Letter No. M/1544/05

Sub: CMDA - Planning Permission - Construction of SH² UR + GP + FF +

2FF of Residential/Commercial Building with 4 d.v. on plan no: 71B,
over no: 162/2 (new) 155(ol) T.S. no: 191, B.C. no: 24
of (Comm) village.

Development charges and other charges to be
remitted - Regarding.

OFFICE COPY

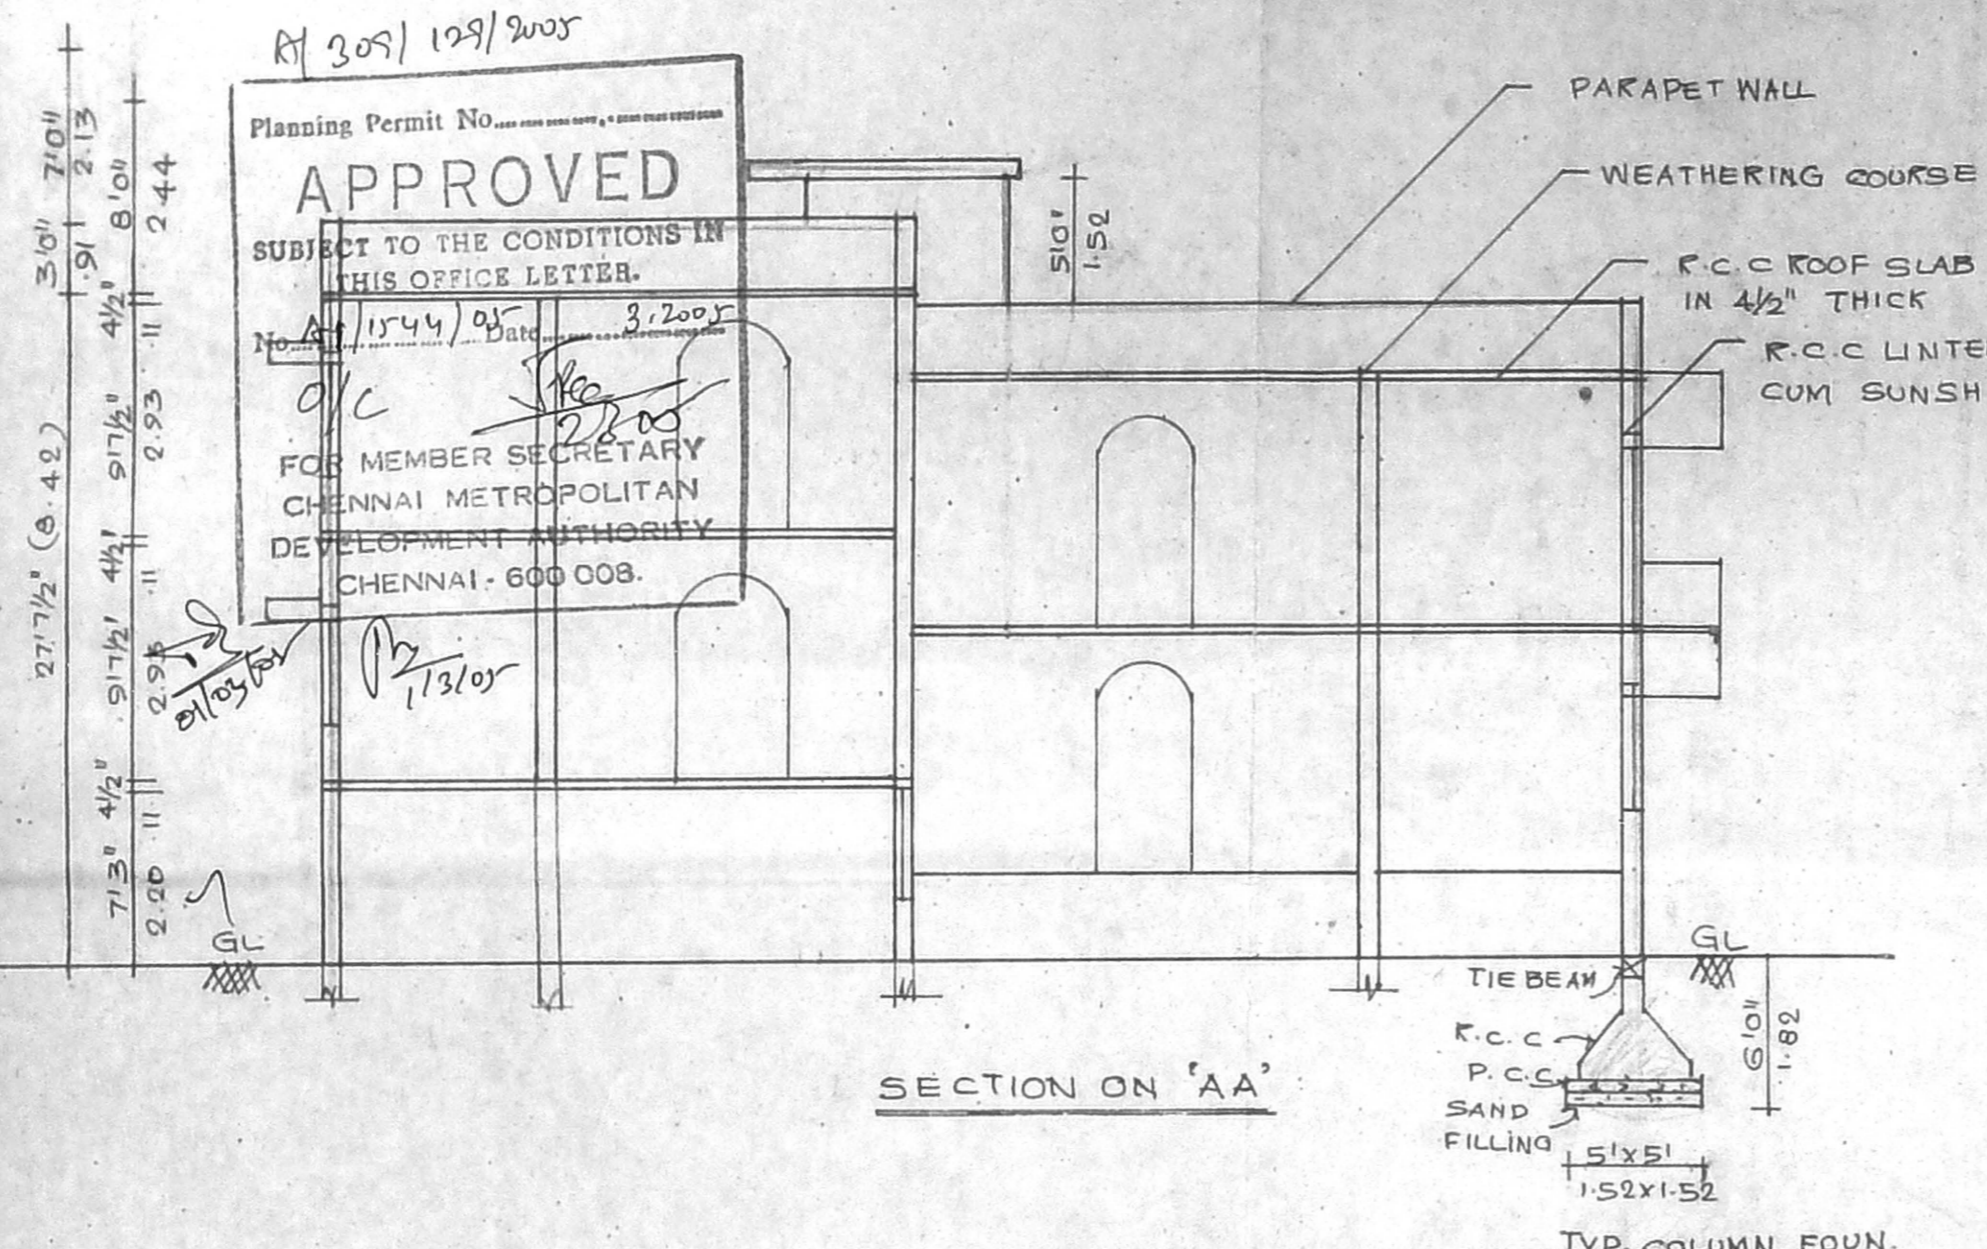
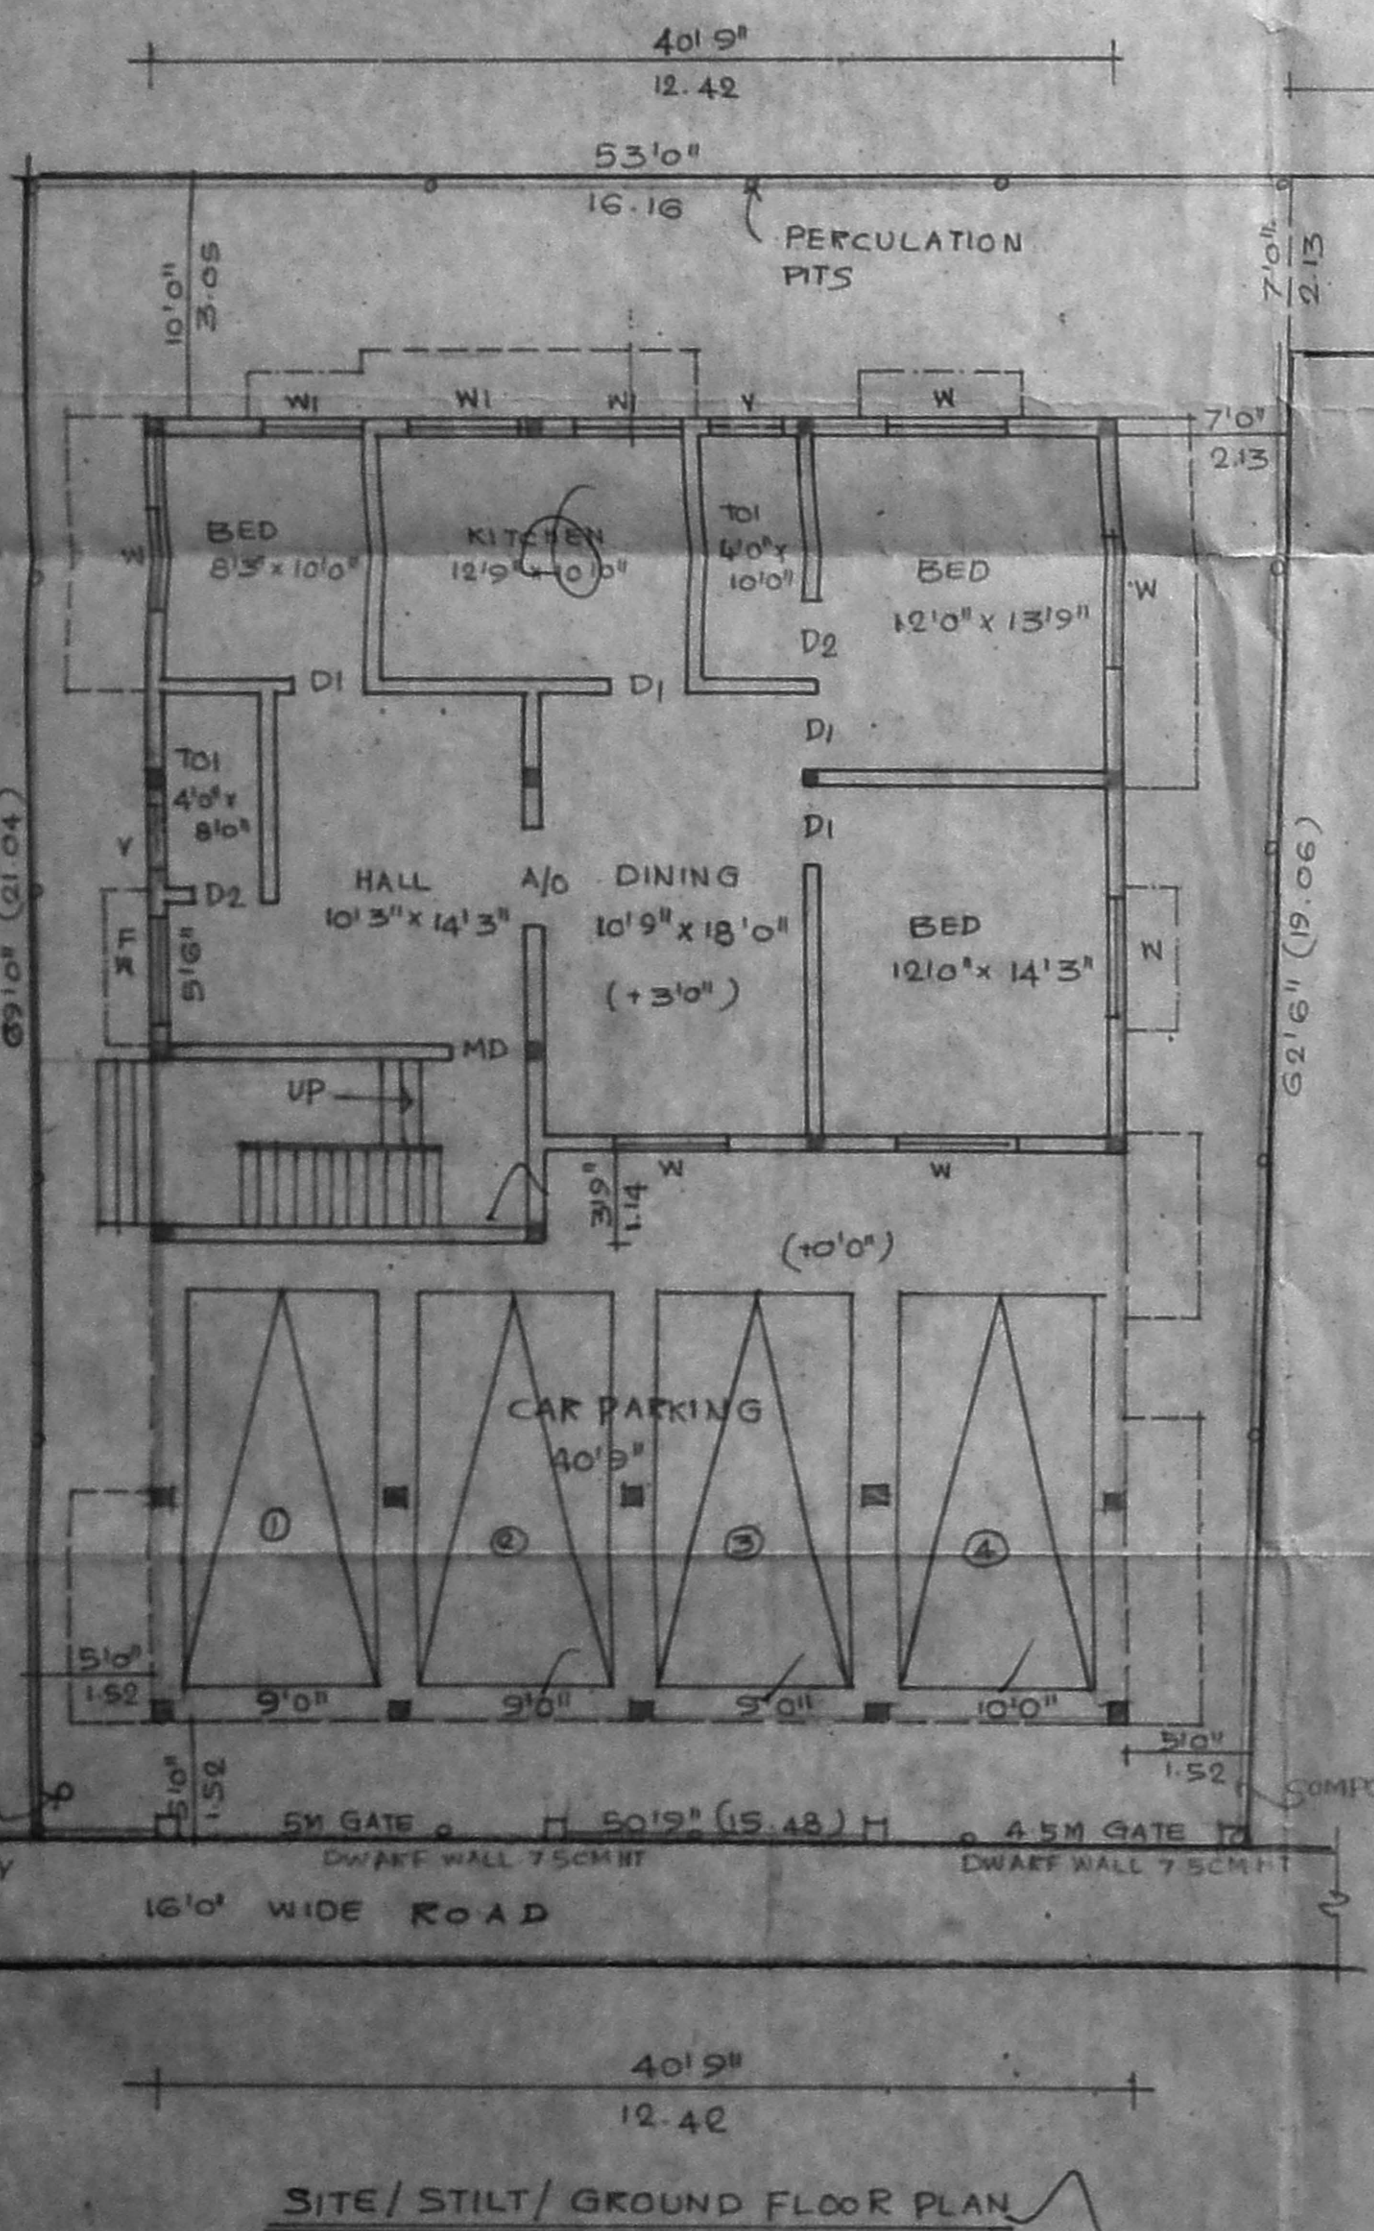
- (i) Plot no: as per SD Plan and write man title to plan.
- (ii) Now shown as show plan is not feasible.
- (iii) Elevation to be covered w.r to window/door @ hill.
